RE: Coors Storage – Project#1003993; Zone Change & Site Development Plan for Building Permit 18EPC-40018 & 18EPC-40020

The purpose of this letter is to transmit the Site Plan for Building Permit to the Development Review Board for final sign-off. The project was approved by the Environmental Planning Commission (EPC) on May 10, 2018.

Project# 1003993
18EPC-40018 Zone Map Amendment
(Zone Change)
18EPC-40020 Site Development Plan
for Building Permit

**NOTE:** BUILDING-MOUNTED SIGNAGE THAT COMPLIES WITH THE APPLICABLE SIGNAGE REGULATIONS IN THE O-1 ZONE MAY BE APPROVED ADMINISTRATIVELY. ALLOWED SIZE IS UP TO 7.5% OF THE FACADE AREA TO WHICH IT IS APPLIED.

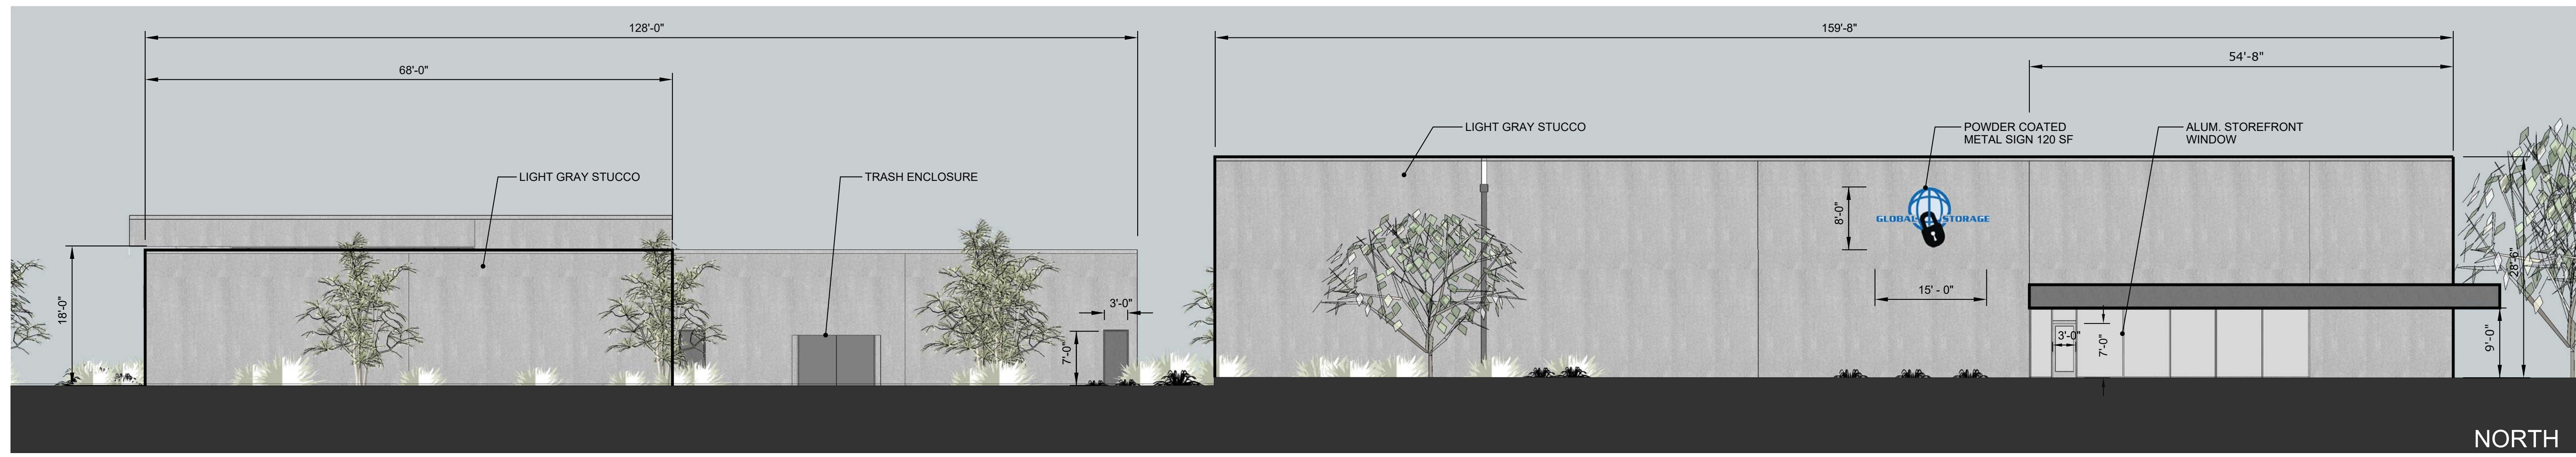
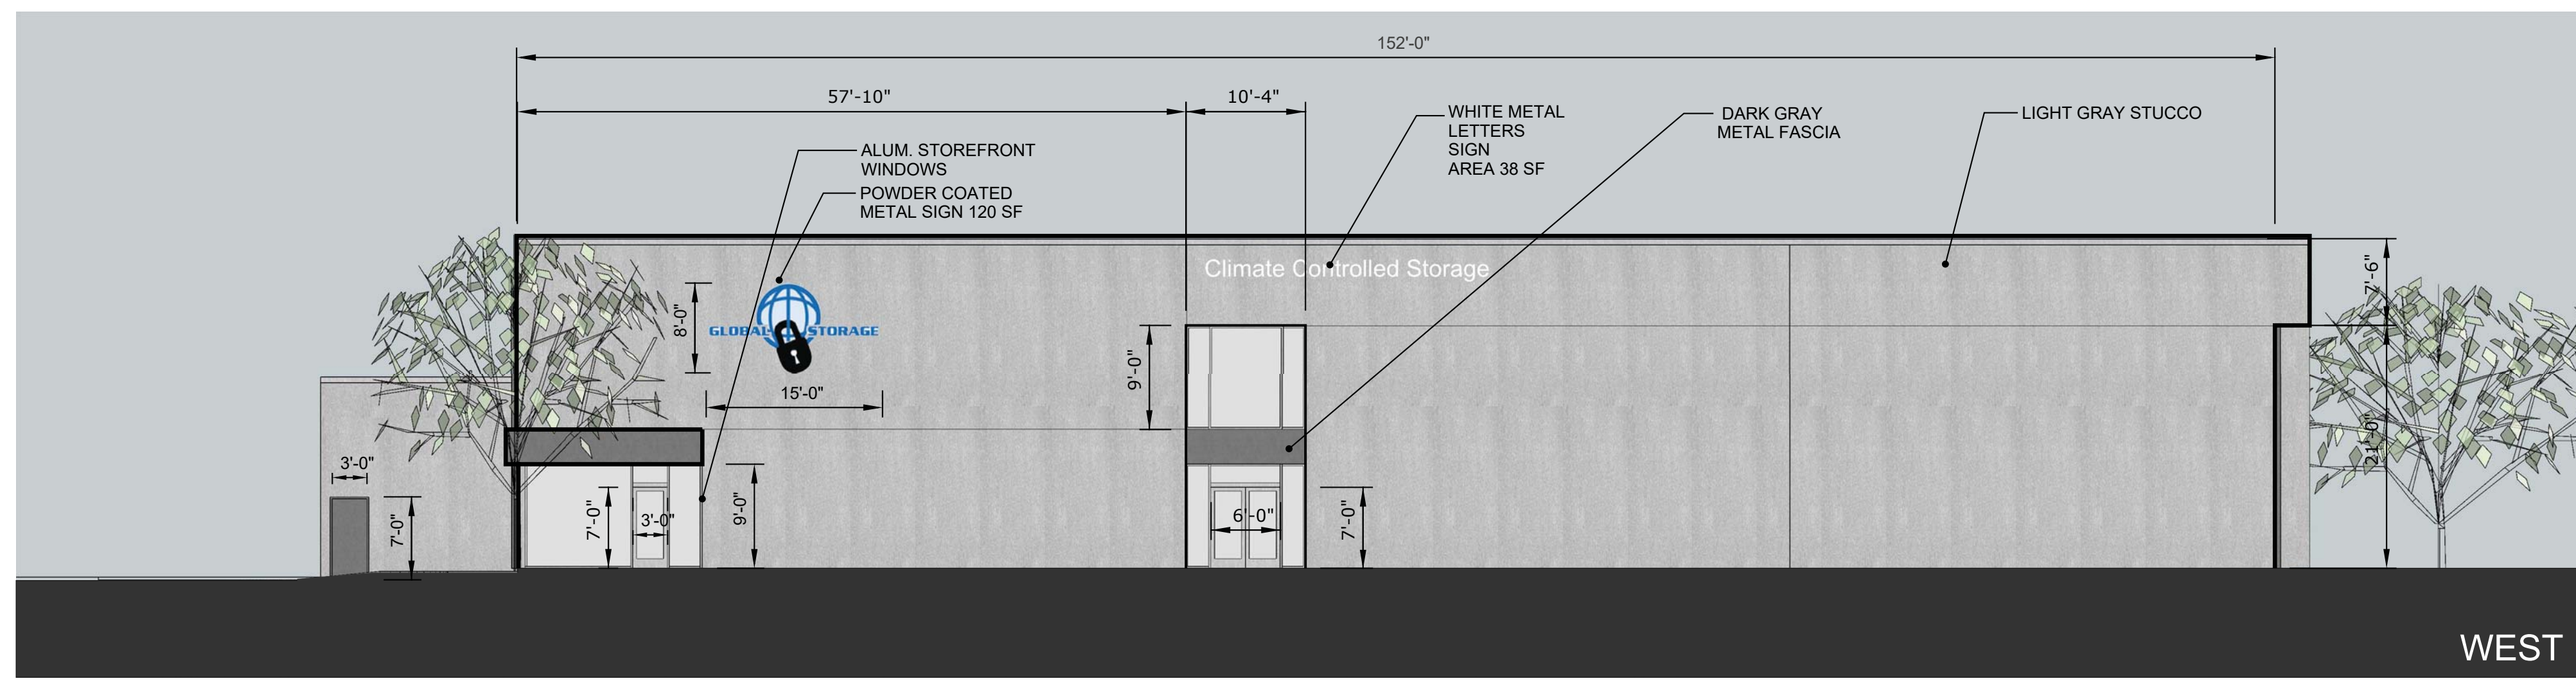
3. Building mounted signage that complies with the applicable signage regulations in the 0- 1 zone may be approved administratively, allowed size is up to 7.5 of the facade area to which it is applied.

Agreed.

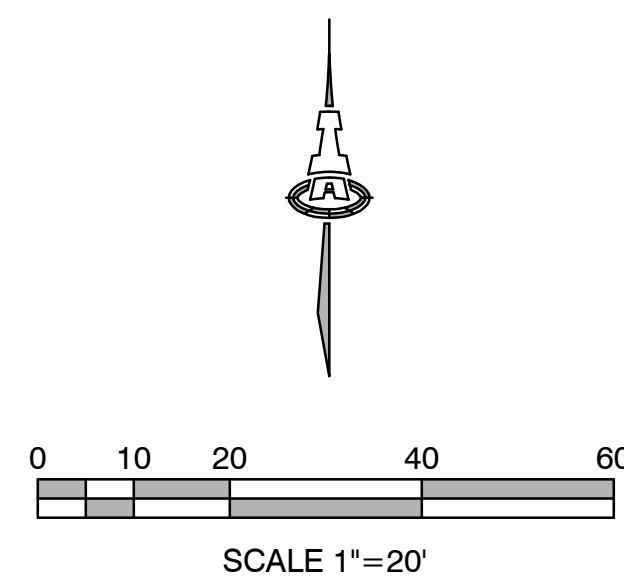
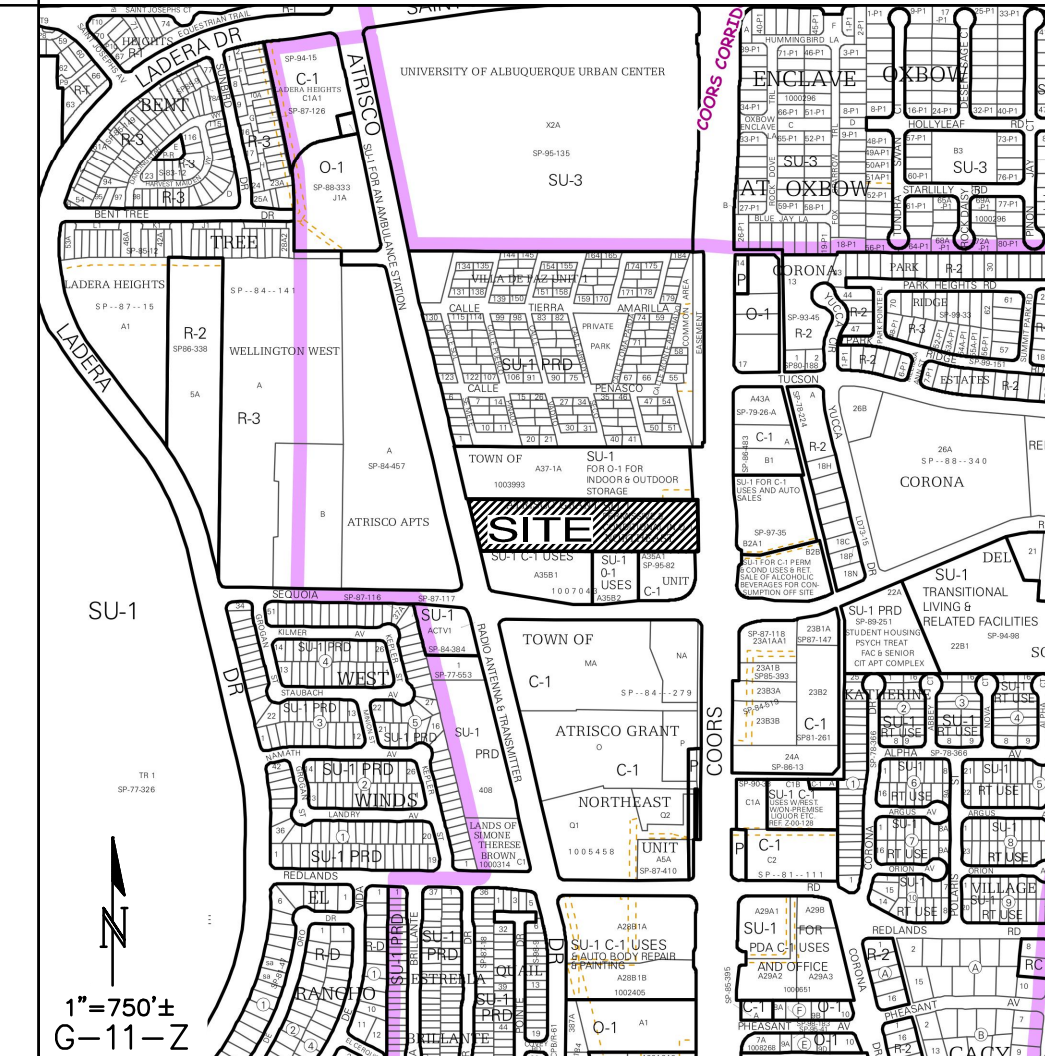
In addition to the permit submission the NMDOT is calling for sidewalk to be established along property frontage for north and south parcels.

Also the NM 45 (Coors Blvd) southbound right deceleration lane shall be reevaluated and lengthened. New deceleration length shall be coordinated with and approved by the NMDOT.

Agreed, the property is working with NMDOT on this request.
